From: Jeff Watson
Sent: Wednesday, October 05, 2011 9:15 AM
To: Chris Cruse (cruseandassoc@kvalley.com)
Subject: BL-11-00024 Otte

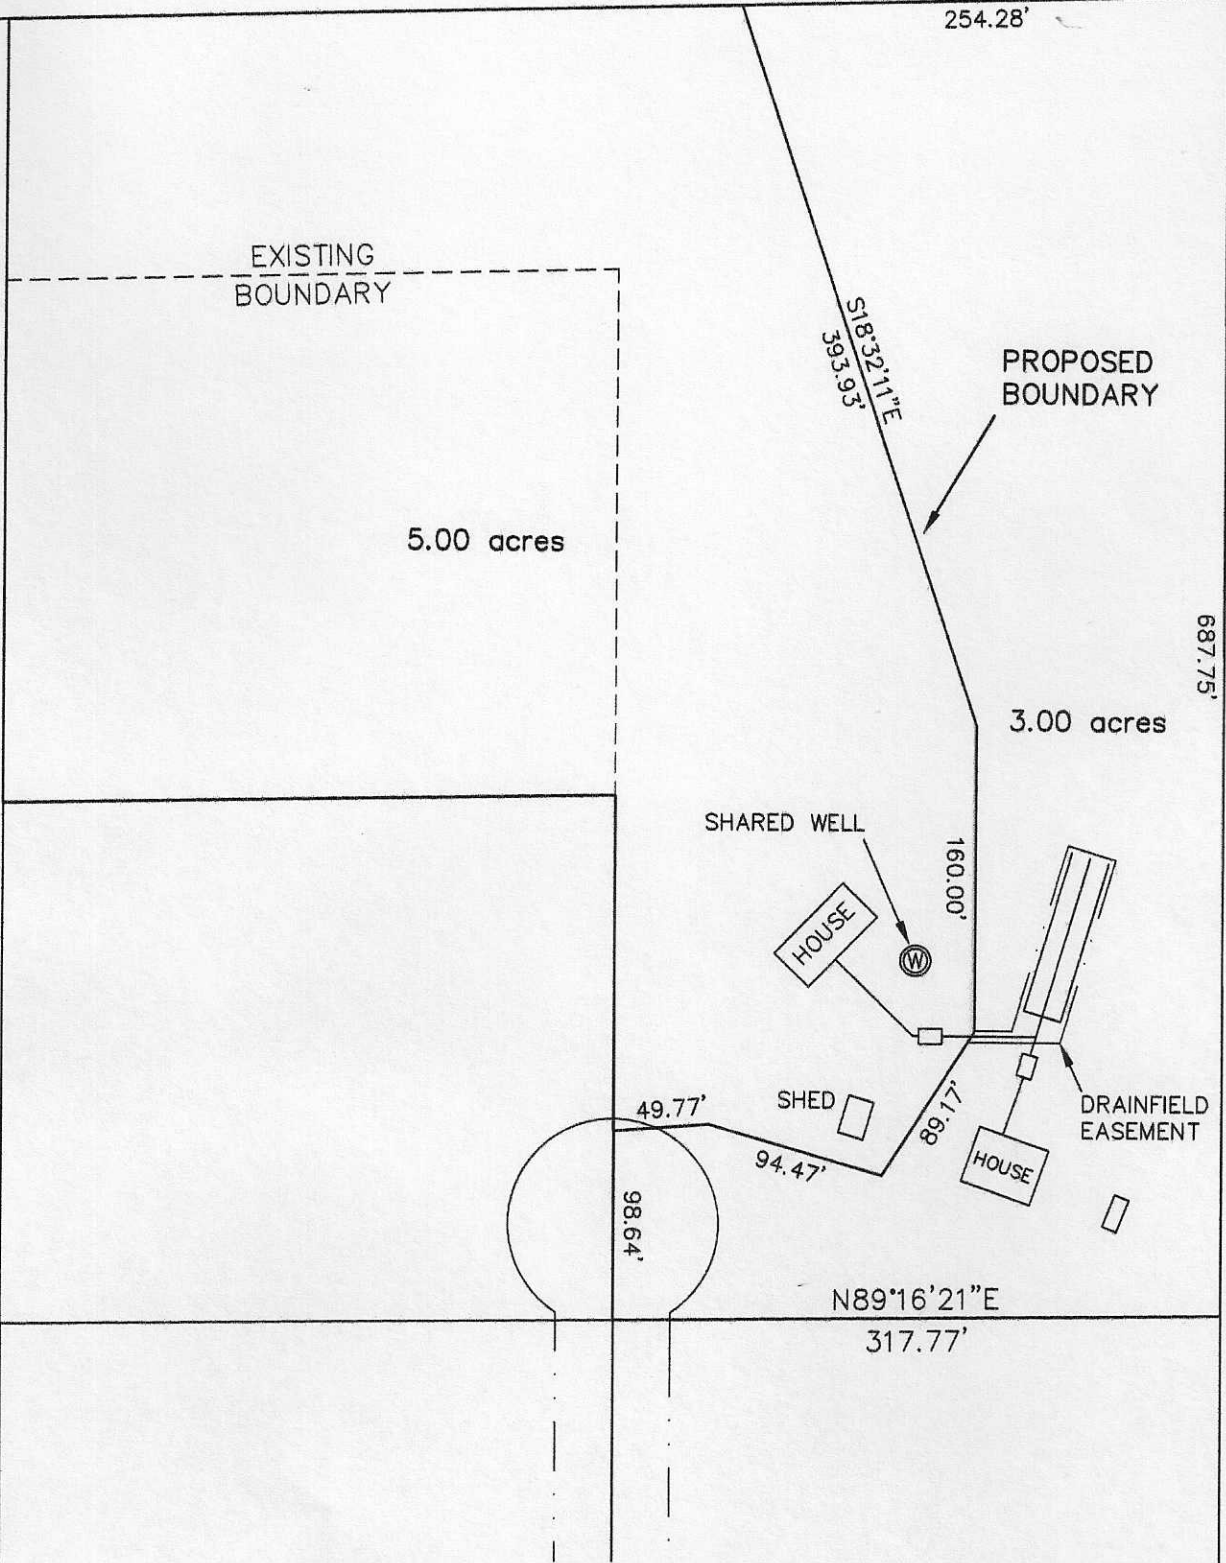
I also have questions on this one. It appears that the proposed project will have a lot line going through the area where the house, well site and drainfield might be. I need a better site plan showing the location of the well and on-site sewage system in relation to the proposed lot line. Can the applicant provide this?
